Transport
for NSW

**State Significant Development – Norwest Private Hospital Expansion,
11 Norbrik Drive, Bella Vista (SSD 13_6074) Notice of Exhibition**

Thank you for your letter dated 6 December 2013 requesting Transport for NSW review and comment on the above State Significant Development.

STAGE 6
Basement Floor
10 car spots lost

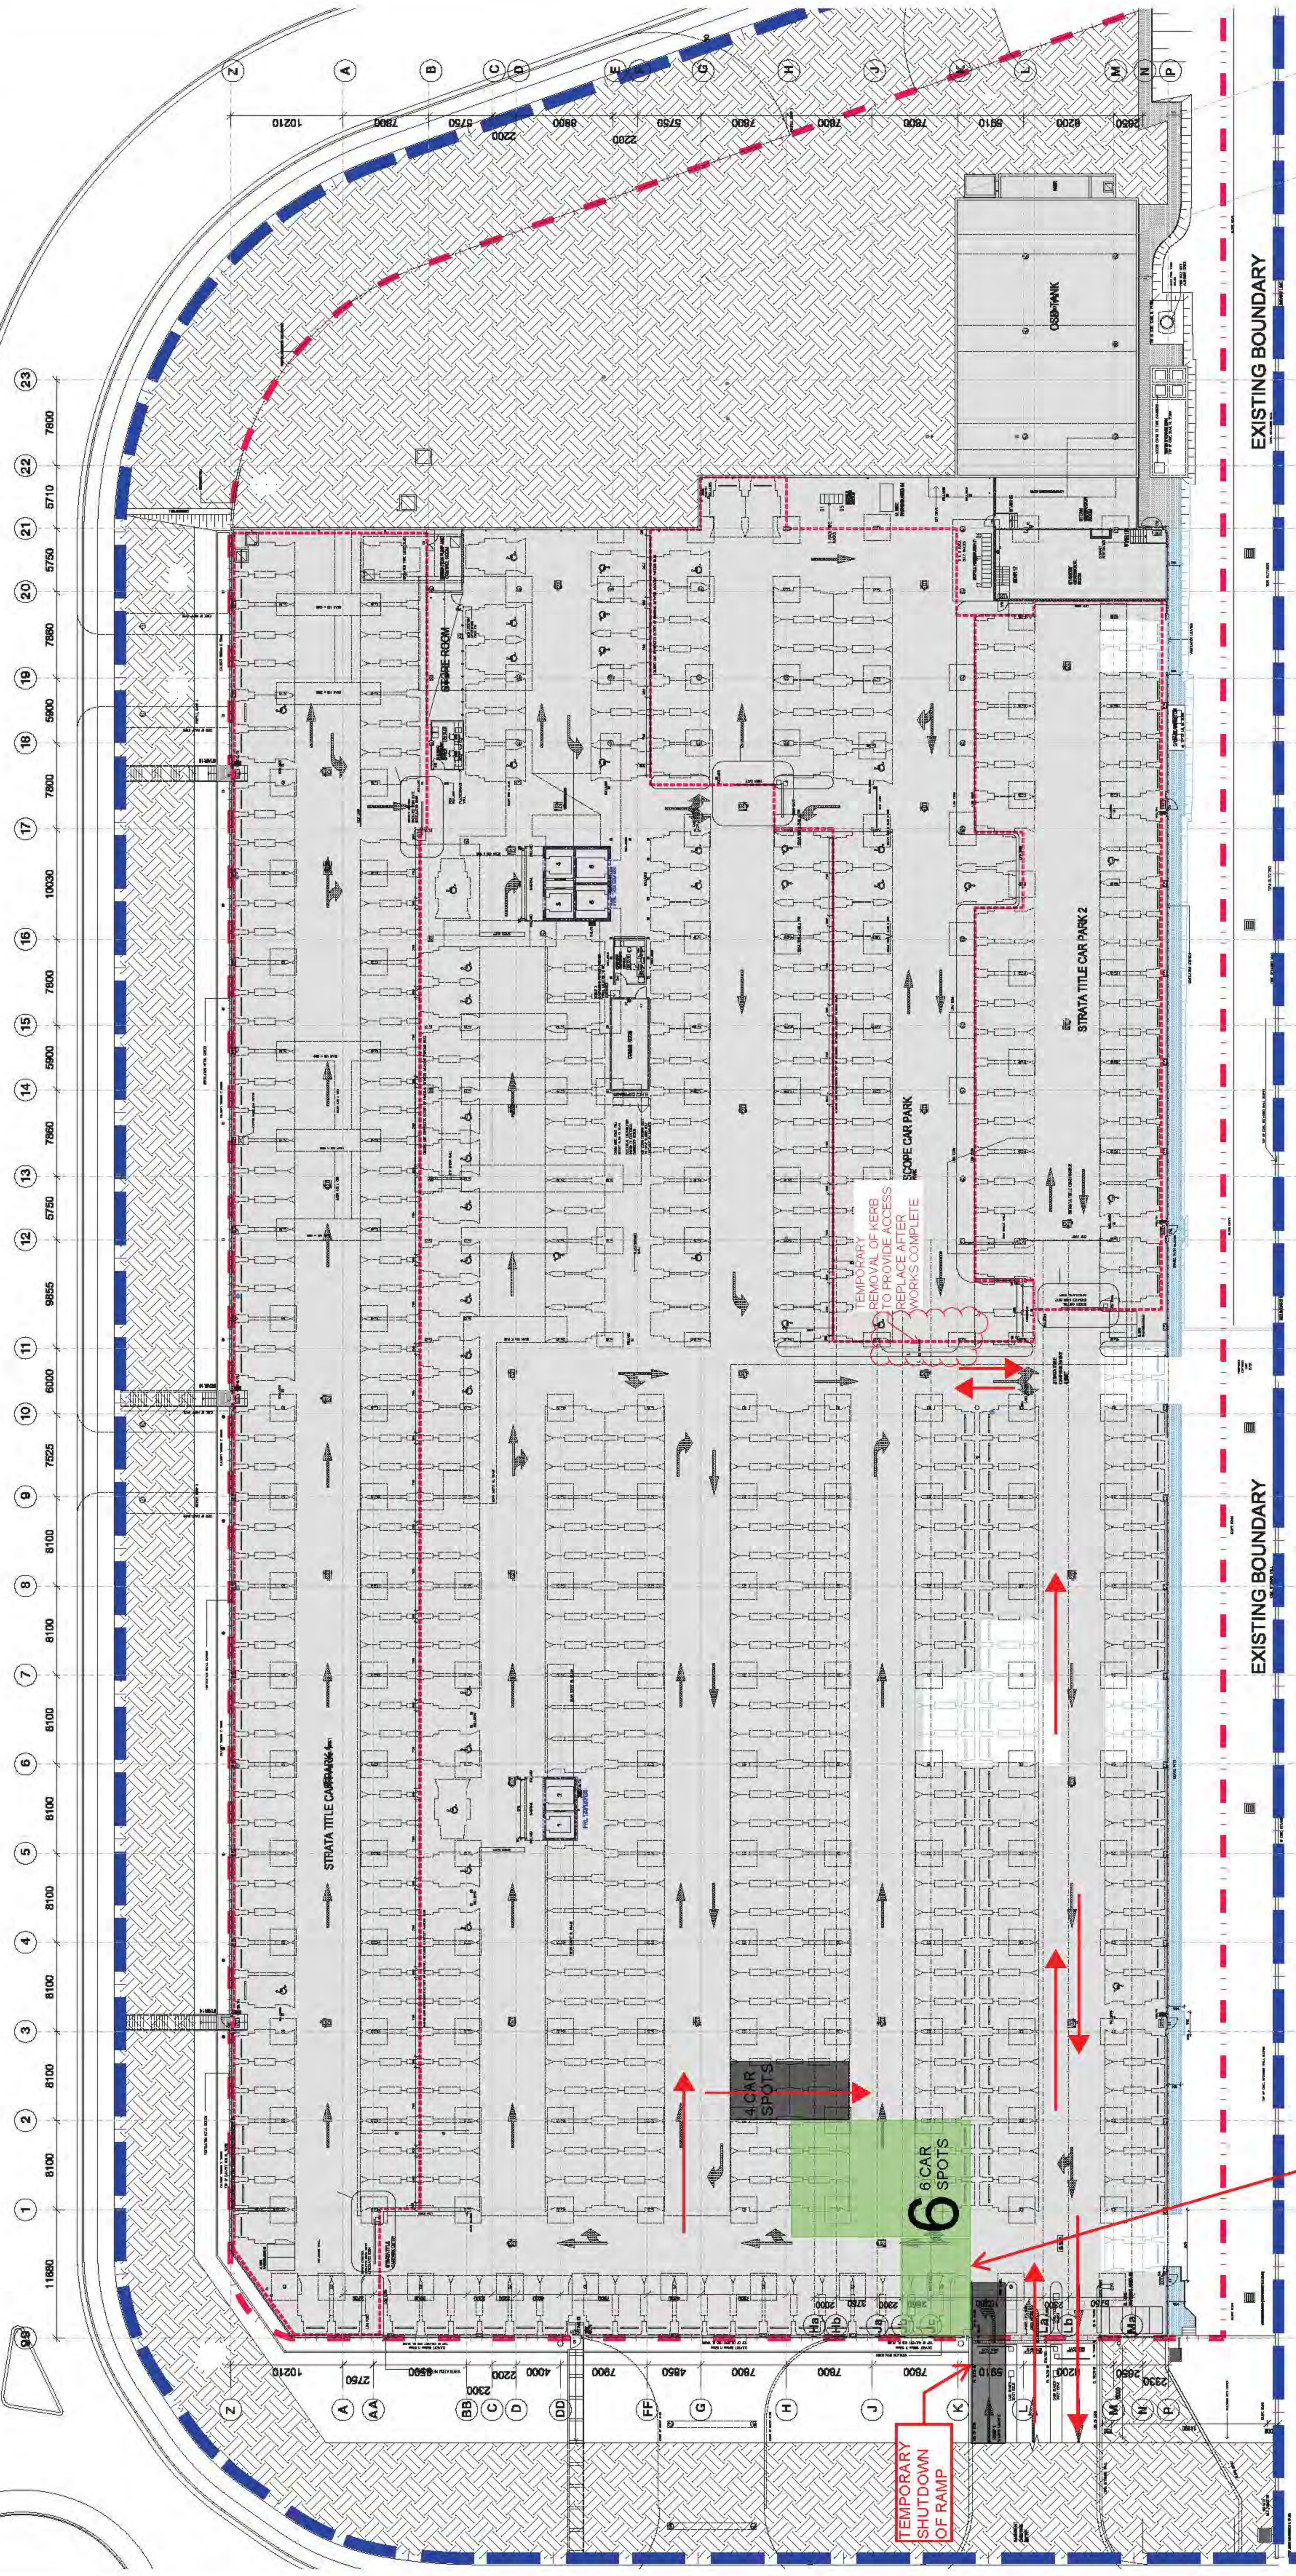
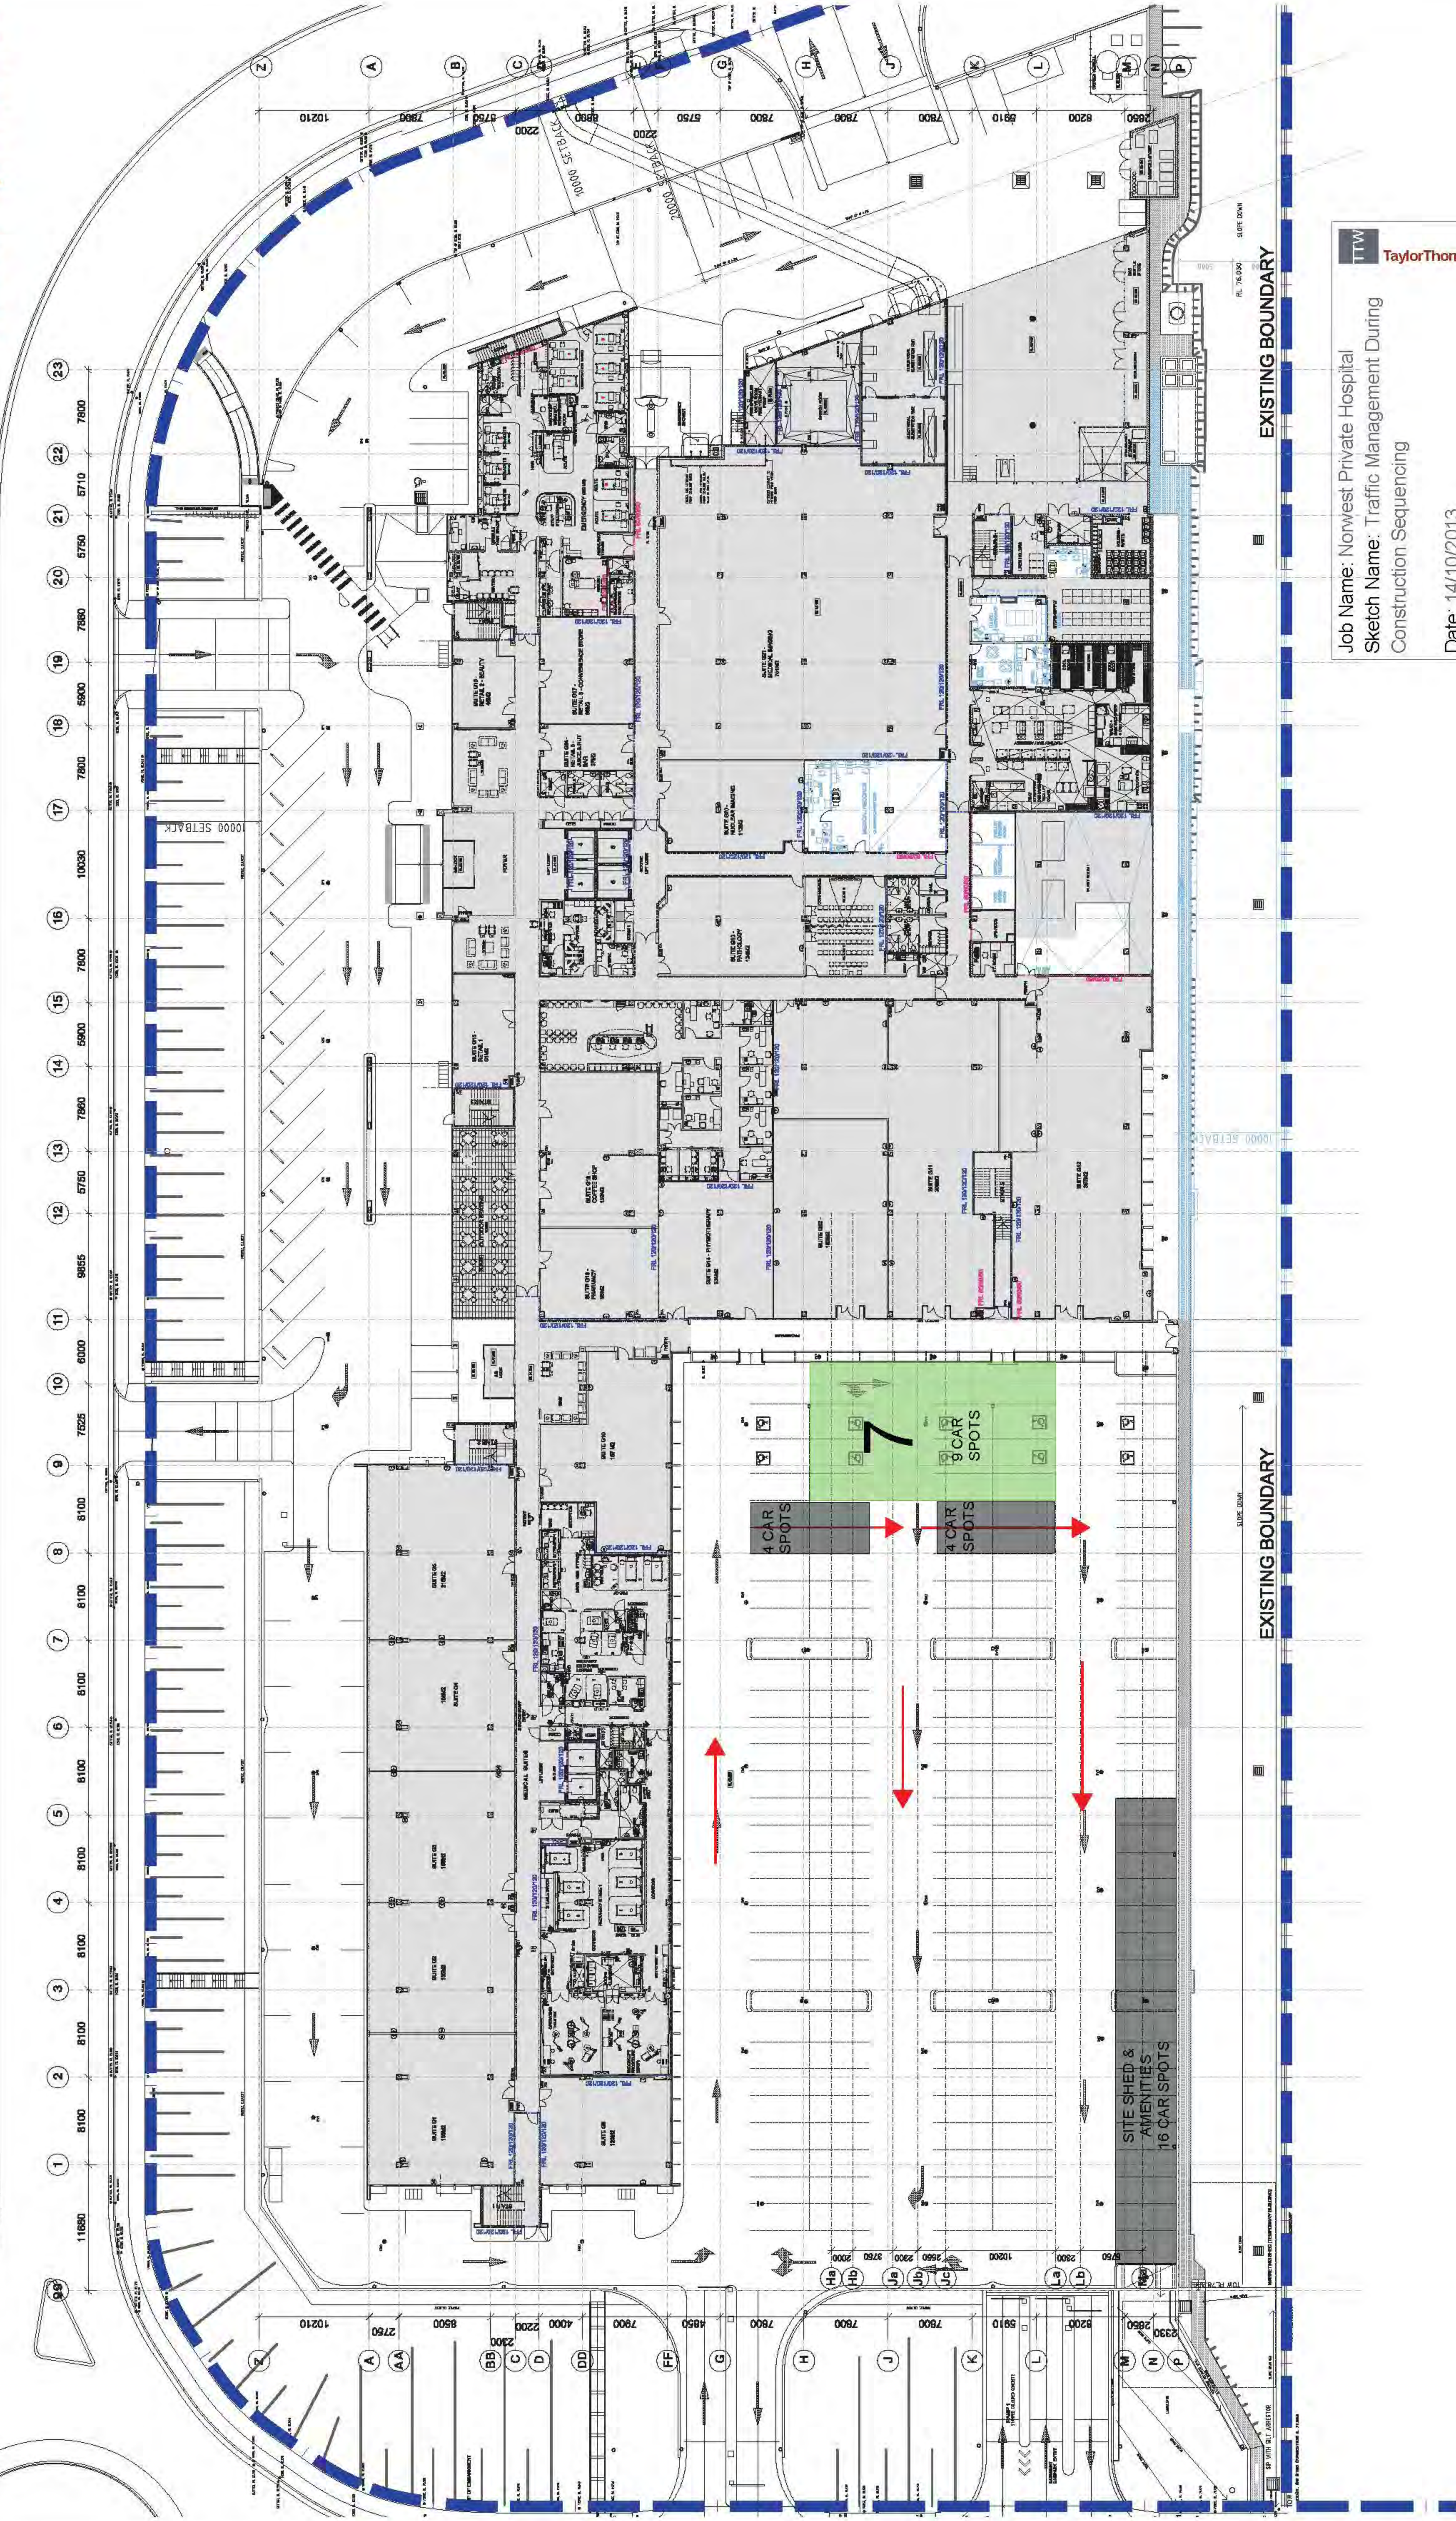
- Conditions of development consent should include the need to prepare a Traffic Management Plan for Construction Activities (TMP), which should detail construction vehicle routes, number of trucks, hours of operation, access arrangements and traffic control measures to undertaken during the construction phase of the project. The TMP should be submitted for review and approval prior to commencement of any works on site.

- The TMP does not provide information on the potential construction traffic impacts to bus services operating within the vicinity of the site. Transport for NSW considers that it is likely there would be impacts to bus services as the proposed construction vehicles route around the hospital site is the same as that for bus services. Transport for NSW recommends that any development approval include a condition that the construction of the hospital expansion be undertaken in a manner that does not create any safety concerns and minimises disruption for bus services.
